Appeal Decision

Appeal Ref: APP/R5510/W/22/3301645

170 Harefield Road, Uxbridge UB8 1PP

- The appeal is made under section 78 of the Town and Country Planning Act 1990 against a failure to give notice within the prescribed period of a decision on an application for planning permission
 - The appeal is made by Toast Developments against the Council of the London Borough of Hillingdon.
 - The application Ref 23469/APP/2022/144, is dated 17 January 2022.
 - The development proposed is erection of new 3 bedroom bungalow with dormers and rooflights serving accommodation in the roof on land to the front of existing dwelling.
-

SK3/A

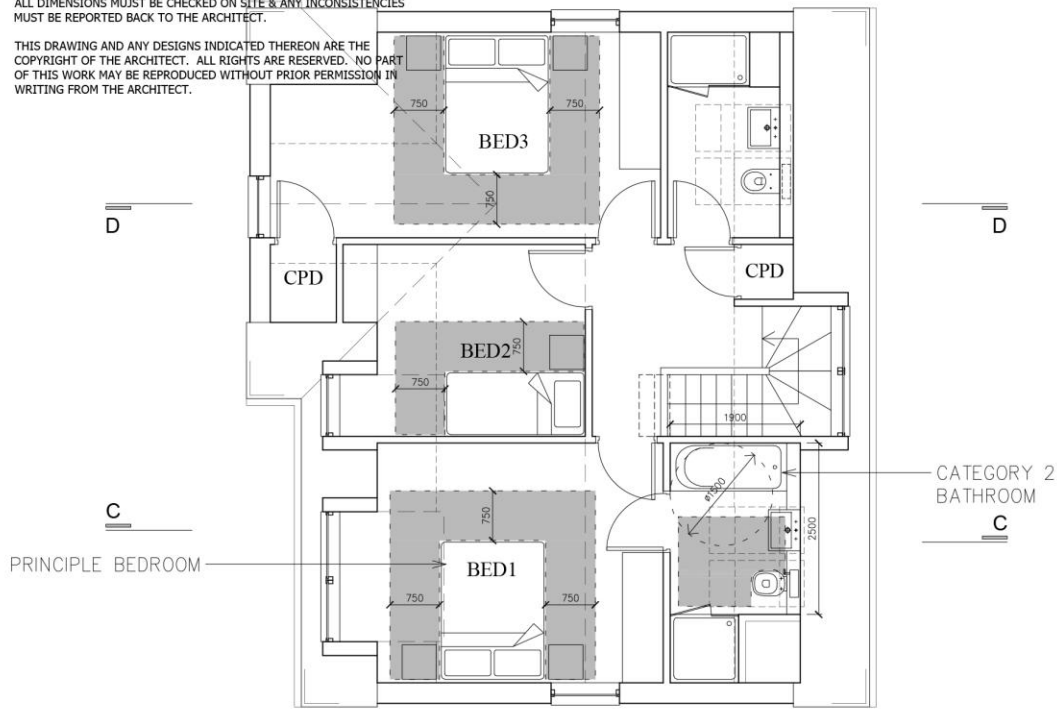
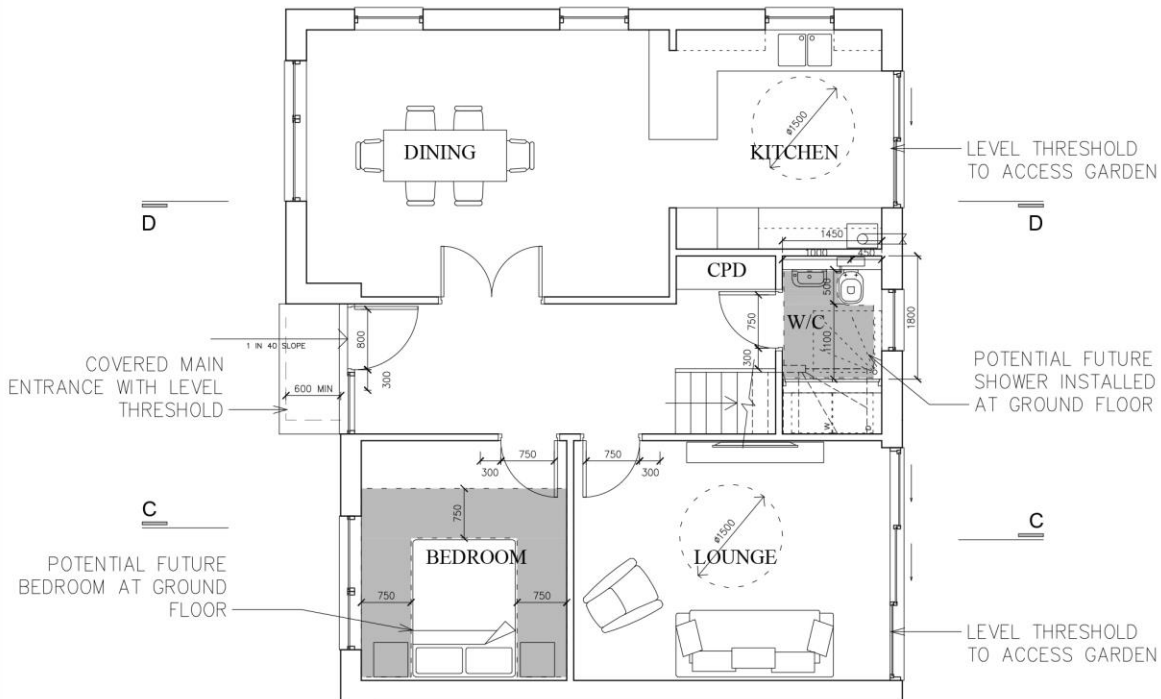
21. In response to concerns raised by the Council, the appellant's evidence clarifies that local ramping could provide for level thresholds to the dwelling so that step free access would be possible. They have also submitted a plan showing updated ground and first floor layouts (drawing ref SK3/A) indicating how prescribed standards within requirement M4(2) including for clear access zones and spatial standards could be met. Having considered the submitted details, I am satisfied that any amendments necessary to meet M4(2) requirements would be very minor affecting the internal layout and landscaping only, and I see no reason that compliance could not be achieved. In these circumstances, I find that it would in this case be reasonable to secure further detail and compliance by way of a planning condition.

22. Subject to this condition, I conclude that the development would make adequate provision to meet the requirements for accessible housing, and it would accord with LP Policy D7.
